KITTITAS COUNTY COMMUNITY DEVELOPMENT SERVICES

RE: Shoreline Exemption Permit (SX-25-00011 McDonough) – Deemed Incomplete – Request for Additional Information

Drawing file: SX-25-00011 McDonough / PSA-25-00186  - Initial Shoreline Review - Site Plan.pdf

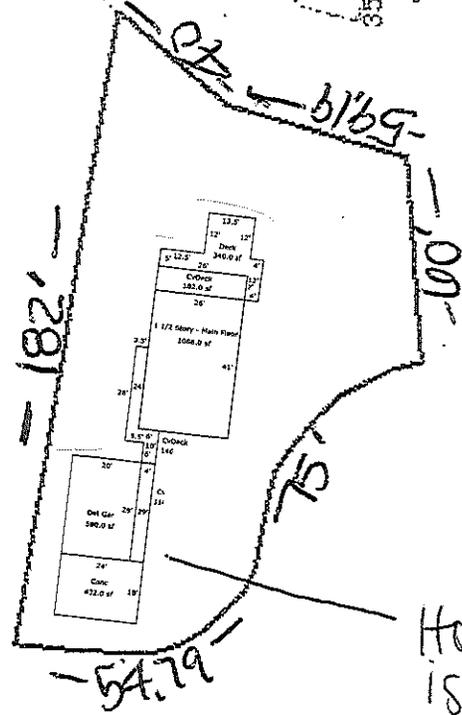
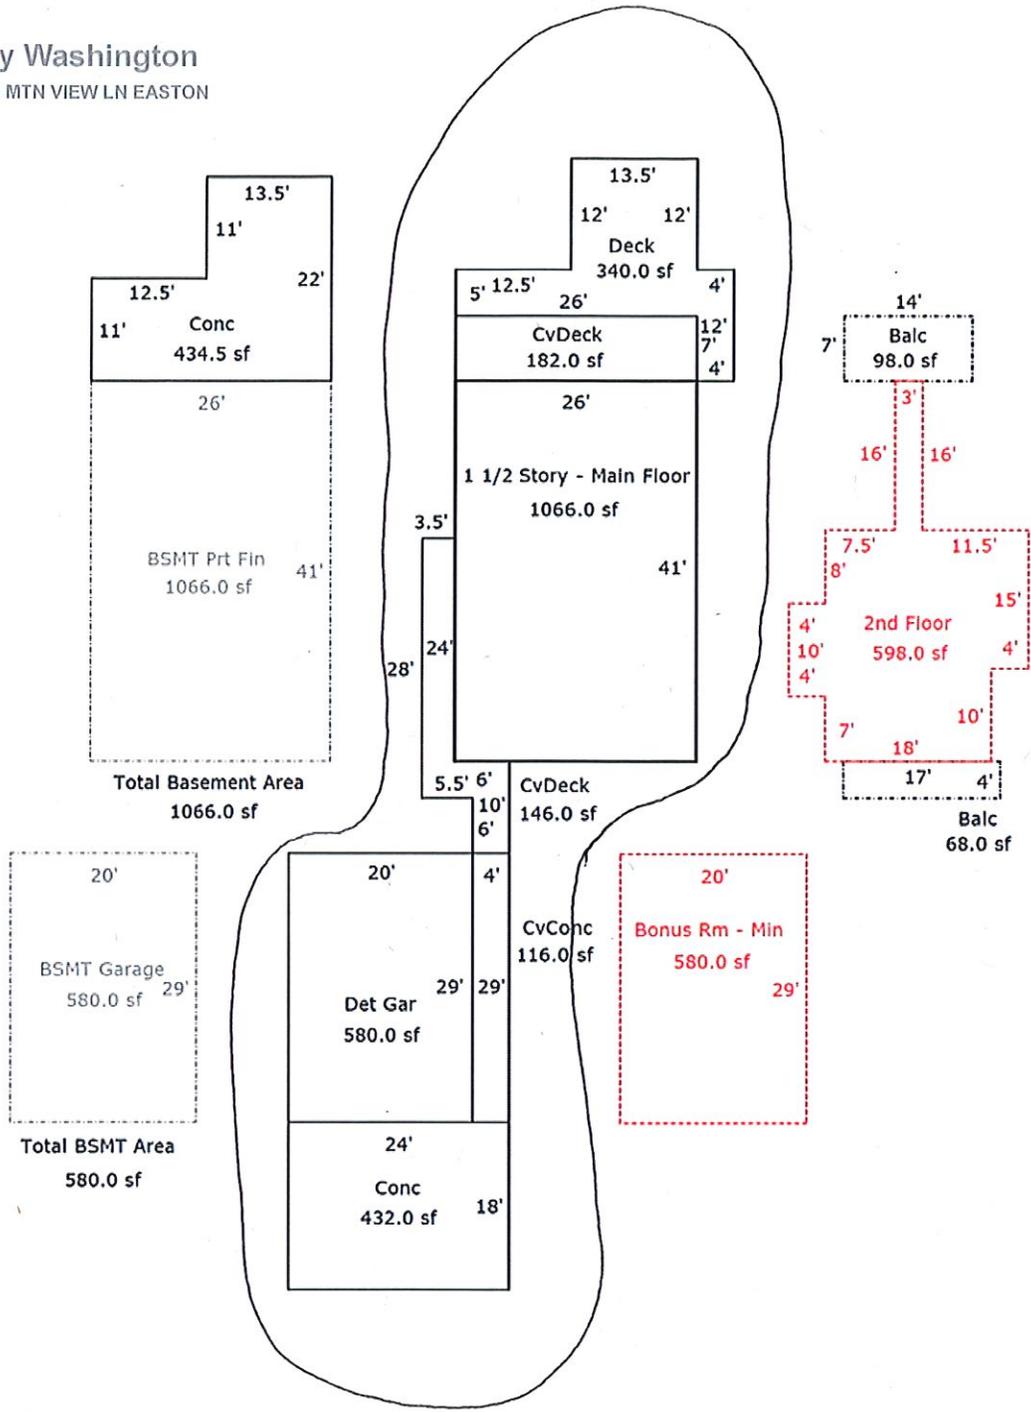
1. Please provide an updated site plan showing the exact location of all proposed structures, septic system components, drain fields, etc. In addition, please provide their dimensions, as well as each component's distances from property lines, rivers, and horizontal distances from the Ordinary High Water Mark (OHWM).
 - a. Please provide more details on addition to home. What type of additions, building materials, and distances to property lines.
